From: Rebekah Morgan
Sent: 08 August 2022 13:36
To: DC Support
Subject: FW: 22/01632/REM - Land Adj To Promised Land Farm, Wendlebury Road, Chesterton
Attachments: LB291_D04b.pdf

Consultation response from landscape officer.

From: Tim Screen <Tim.Screen@Cherwell-DC.gov.uk>
Sent: 28 July 2022 16:42
To: Rebekah Morgan <rebekah.morgan@cherwell-dc.gov.uk>
Subject: 22/01632/REM - Land Adj To Promised Land Farm, Wendlebury Road, Chesterton

Drawing Title:
RM4 - Soft Landscape Proposals
(Sheet 1 of 4)

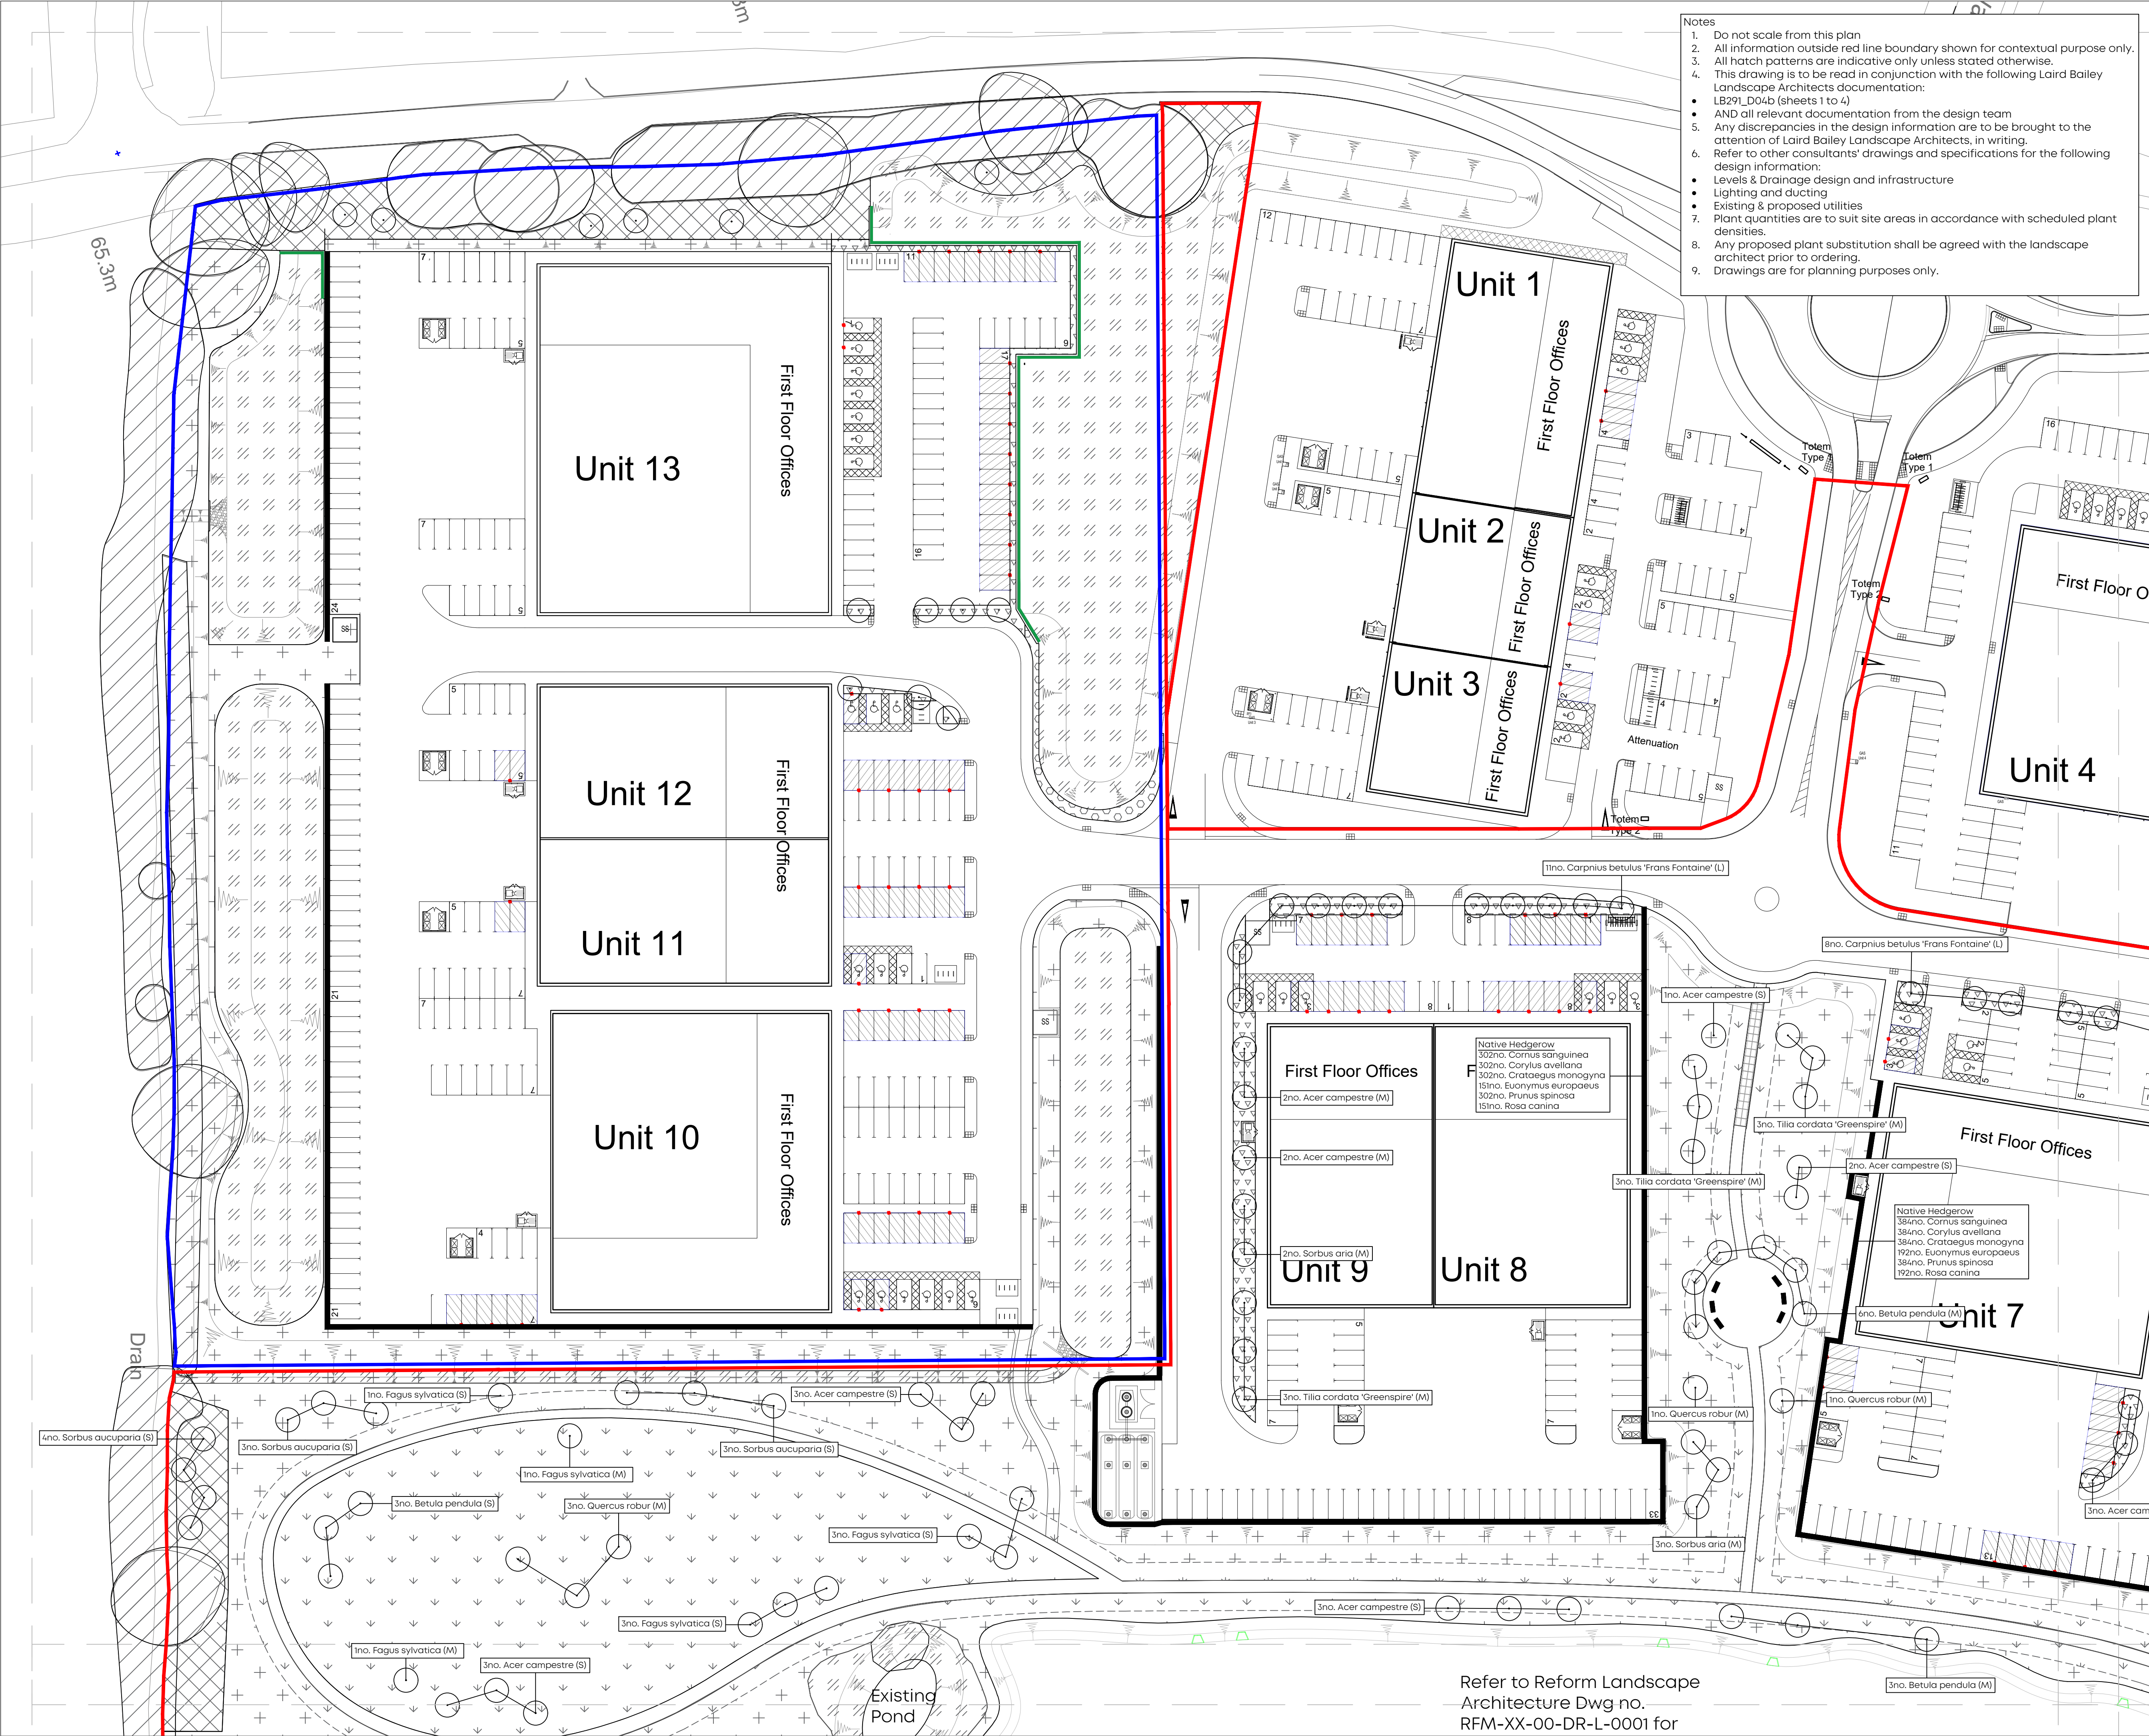
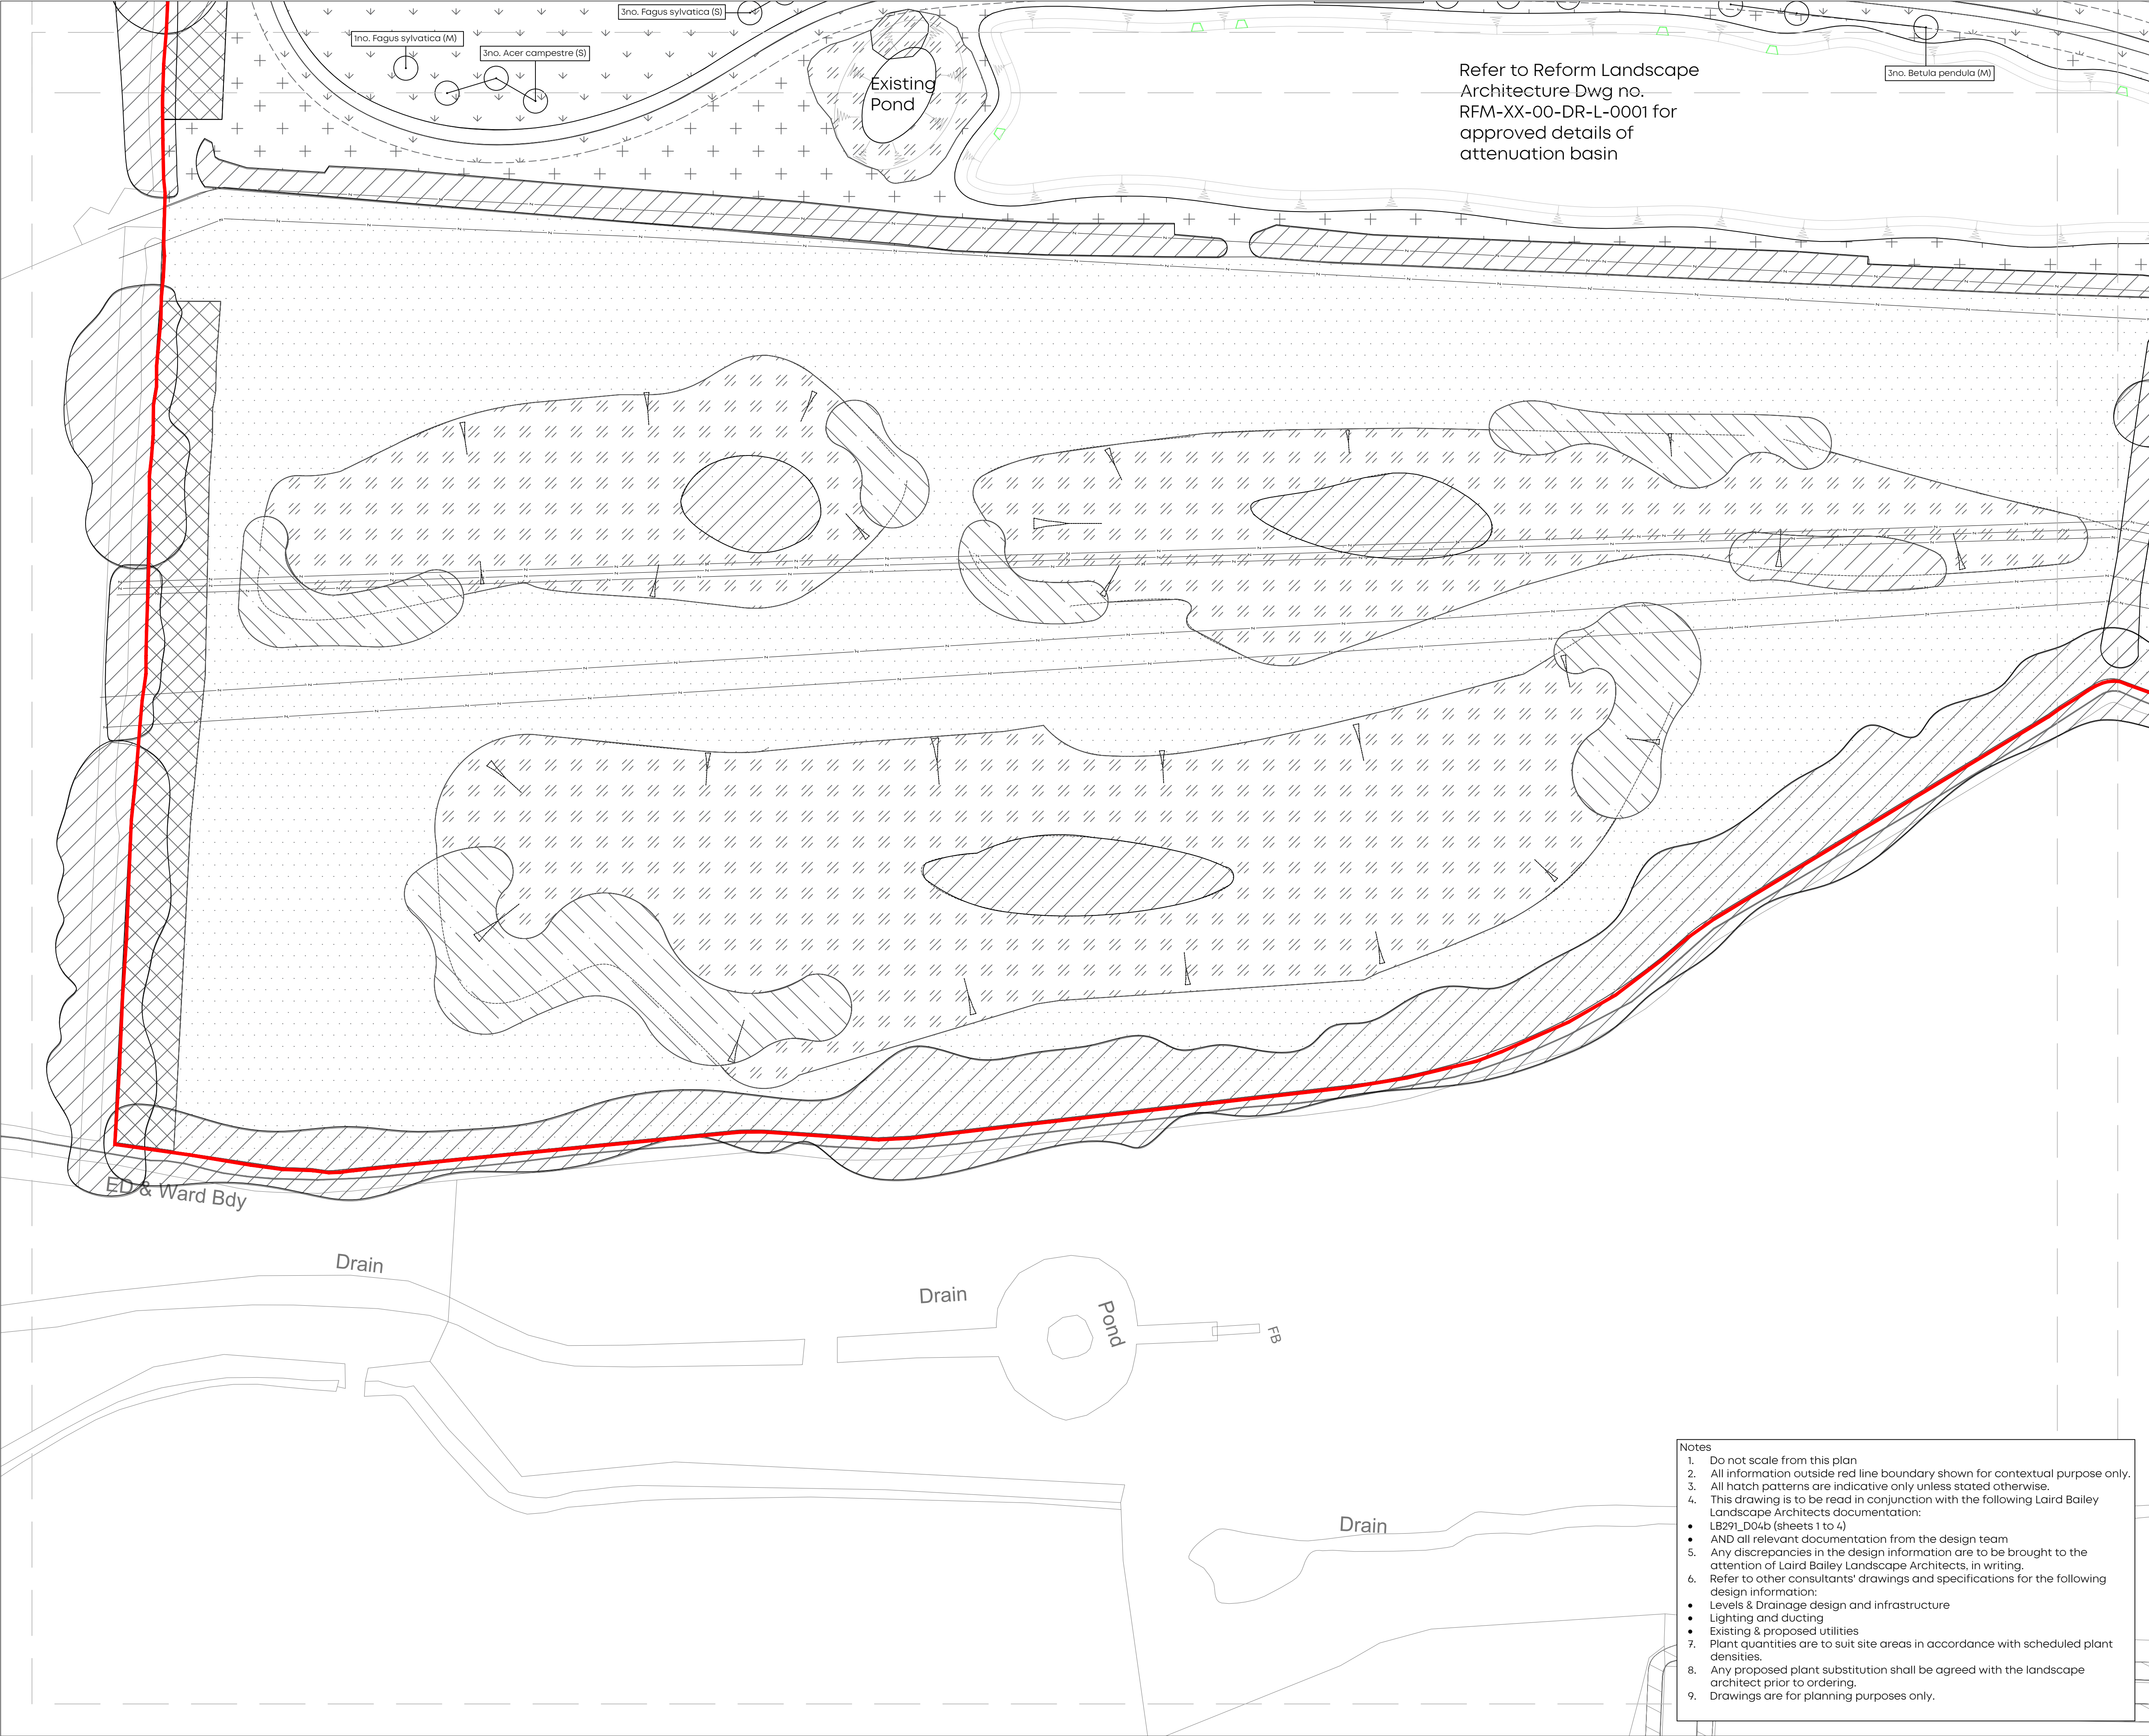
There is an opportunity to increase woodland on the, which contributes towards carbon sequestration/offsetting of development's carbon release, visual mitigation, amenity for site users and wildlife habitat. Woodland areas, with species mixes, supplies sizes and planting densities are required - refer to marked up drawings. The 'oval' spaces east of units 10 and 5. Particular attention paid to ecological ecotone areas: the cross-over of habitats, woodland with woodland edge, woodland edge with herbaceous perennials against wildflower meadow – refer to marked up drawings enclosed.

Where there is plenty of space for canopies spread i.e. central greenspace between units 7 and 8 I would recommend native trees are planted for the habitat this provides for wildlife

Lime Tilia cordata 'Green Spire' should be replaced with T. cordata

Trees planted close to paths and paved surface should be at least 2 m away and a root deflector installed and indicated as such on the drawing.

Tree Pit Detail (for trees in proximity to hard landscaping and services)

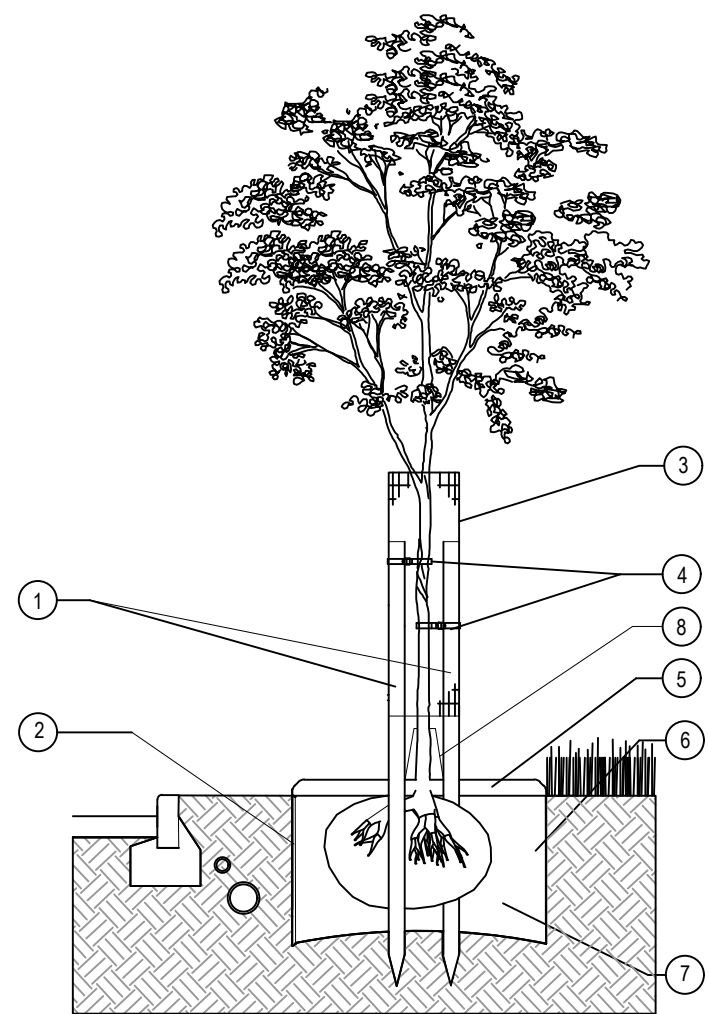
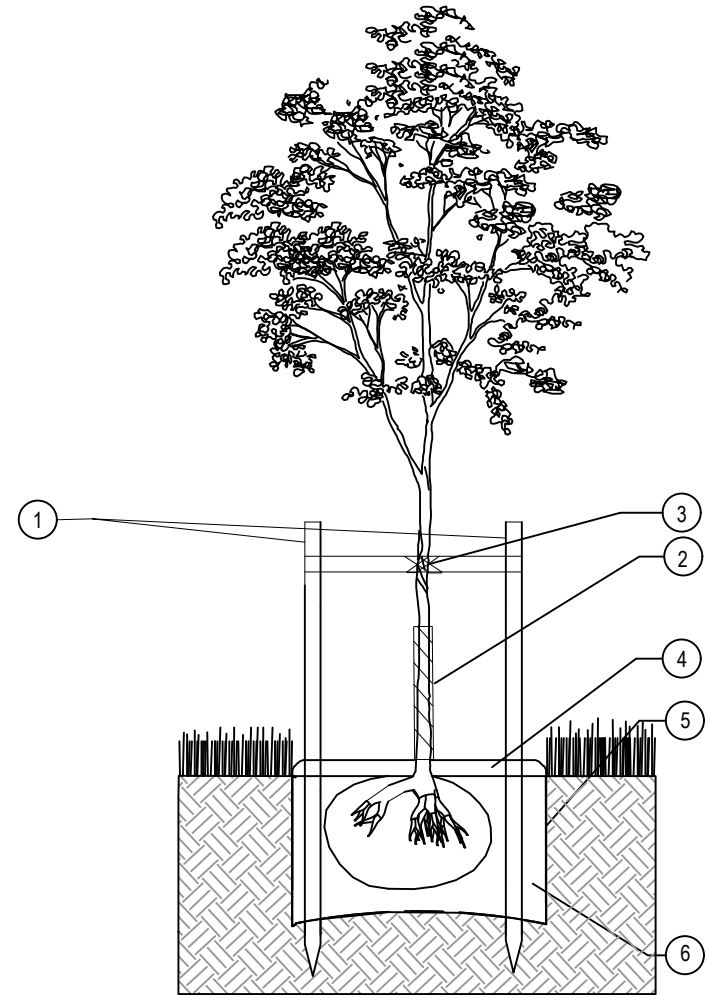
Root flare must not be buried – refer the BS8545: 2014

Refer to item F. The CBR should not be increased by compaction methods. The aim is to ensure adequate drainage where moisture goes deep to encourage deeper root depth and tree stability.
